August 4, 2021

Re: Transportation Impact Study - Revised
Haven Valley – Security-Widefield, Colorado

Aldridge Transportation Consultants (ATC) is pleased to present this Traffic Impact Study regarding the proposed development of Haven Valley in Security-Widefield.

Figure 1

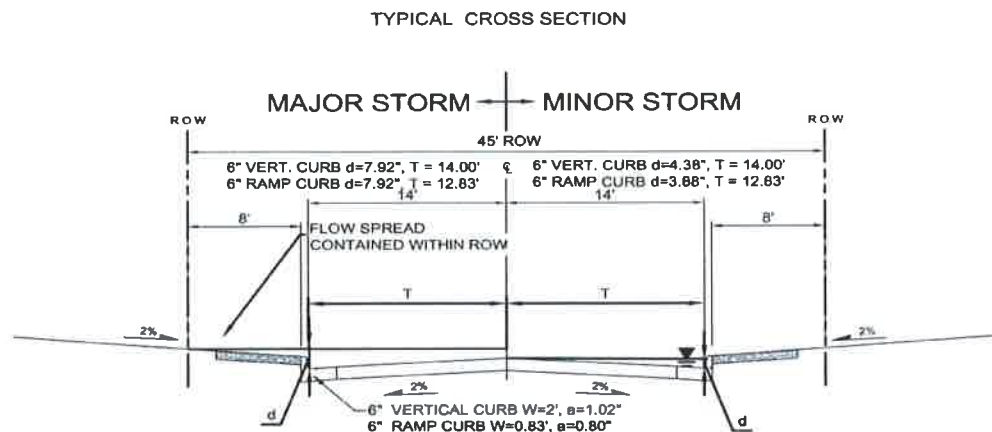
Per the cross section provided on the preliminary plan the internal streets match the urban local low volume cross section in the ECM which have a max design ADT of 300. Please coordinate with your project planner so that the proper roadway cross section(s) and roadway layout is provided on the preliminary plan. Please provide an exhibit showing which roadways are classified as urban local and which are urban local low volume.
